Campbelltown Hospital Redevelopment (CHR)

Clinical Services Building and Associated Works

Consultation Summary

**Figure 21** Level 2 Floor Plan and Main Entry drop off arrangements

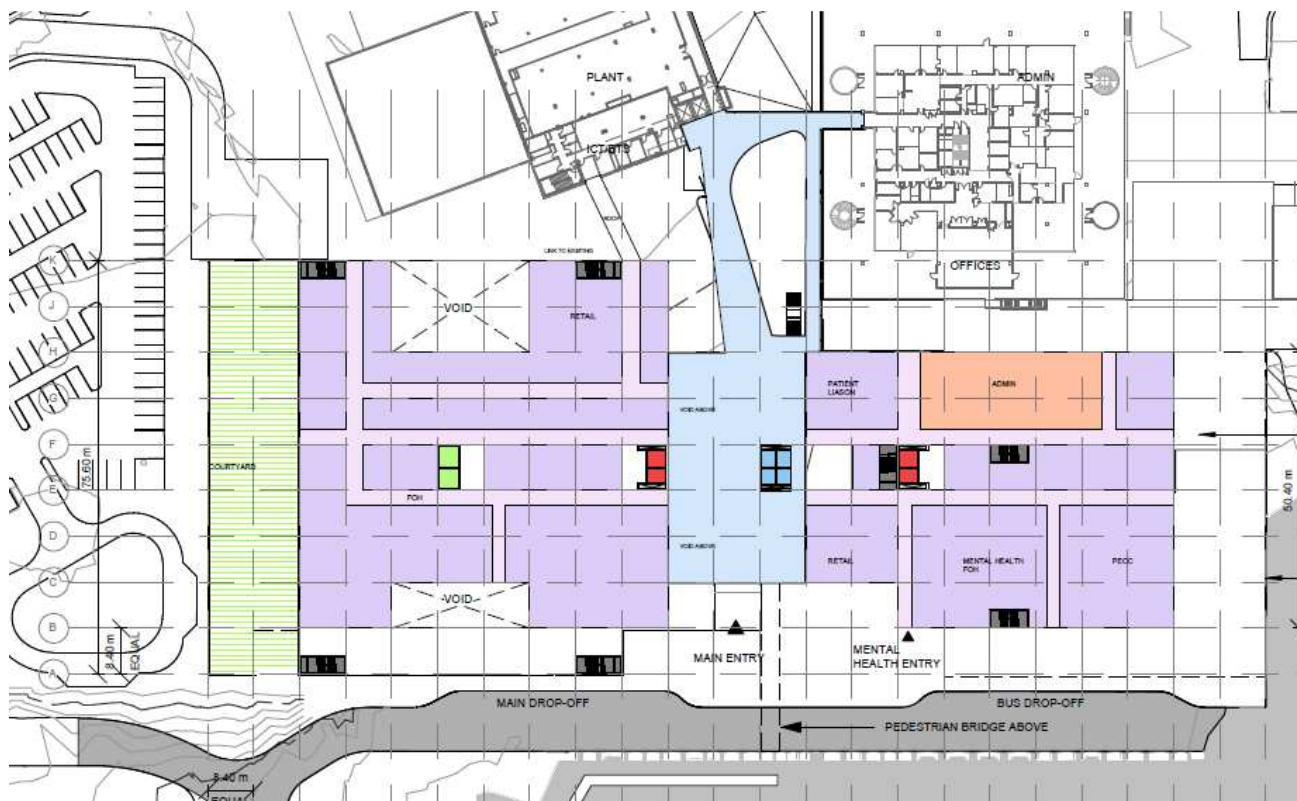
The panel also considers that the single storey height of the southern lobby as the main entrance of the spine is not sufficiently generous for its intended use.

**Figure 24 Hospital Spine**

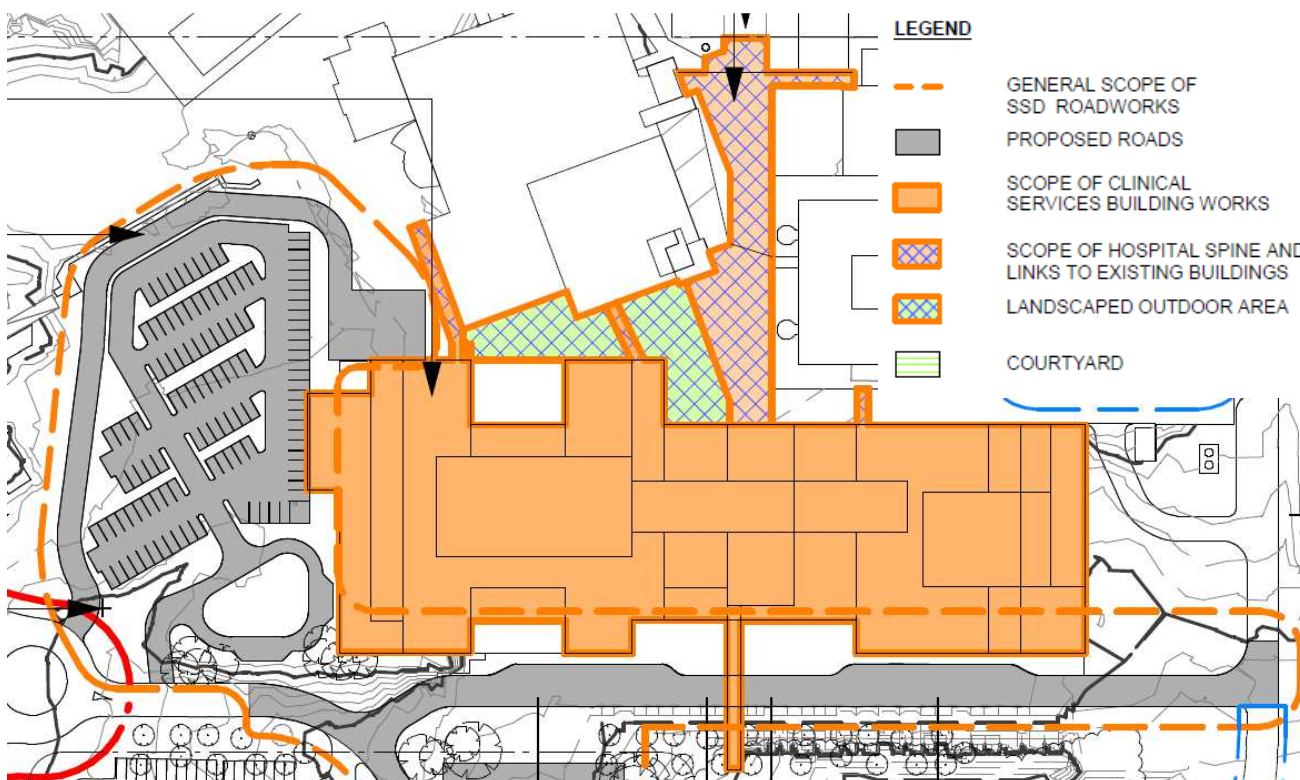
In principle, the panel supports consolidation of circulation between buildings via the central spine and the proposed internal look and feel of the spine as a public space.

Further information is required to understand how the spine contributes to internal circulation and wayfinding in relation to both new and existing wings of the hospital, including internal access to the emergency department.

Further resolution is also required to address the function and program of the spine, including how it is accessed externally and from different levels within the hospital. The panel notes that a pharmacy is currently the only public use proposed and suggests that other public uses might be explored to activate this space.

The panel considers that the visual and physical links between the upper and lower levels of the spine are unresolved. There is concern about use of the existing lifts which are not easily seen when entering the spine from the north. Further, the entry sequence from the north does not allow visual connection up to the main entry level of the atrium and hospital.
